Recommendation Report

Application No. P/90/12

First floor extension to front of property

86 Pagham Road Bognor Regis

FRONT ELEVATION

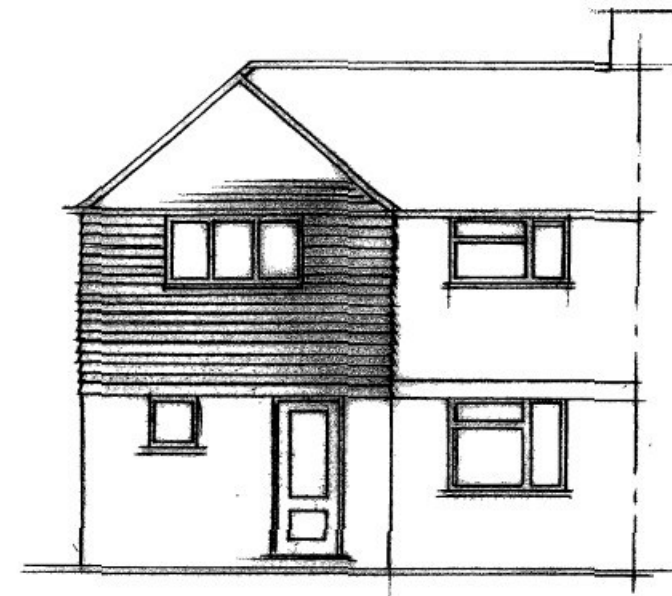
Members were of the opinion that this proposal was totally out of character with the streetscape. It contravenes a number of the elements of the Pagham Village Design Statement, (VDS). This area is addressed in the VDS on page 17 and members wished to draw attention to bullet points 4 ¿Preserve character of area¿, 5 ¿Front boundaries should contribute to overall street scene¿, 7 ¿Extensions in keeping , well-related to existing buildings and space¿, 9 ¿Maintain existing pattern e.g. setback, density¿

Members wondered if a less contentious alternative would be to extend into the garden at the rear of the property.]

EXISTING FRONT ELEVATION.

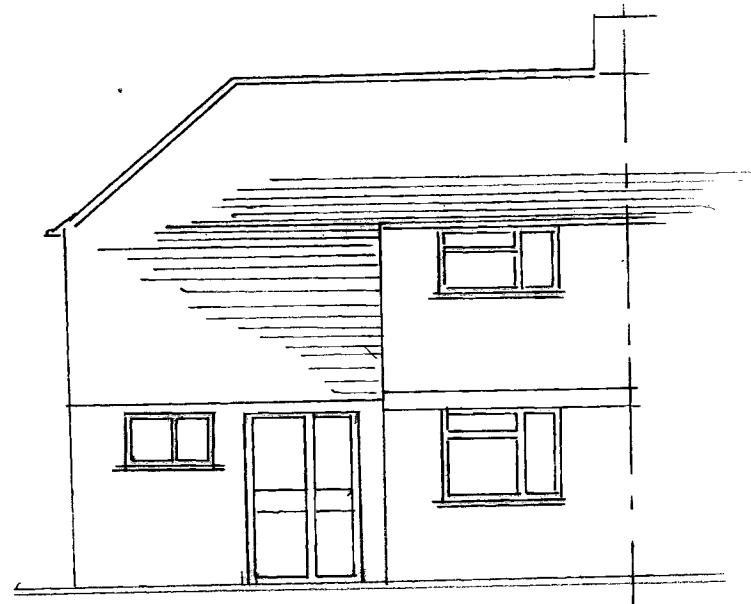
Looks like there is a bathroom window missing on the existing front elevation that appears on the existing front elevation.

Can you pdf me a new plan?
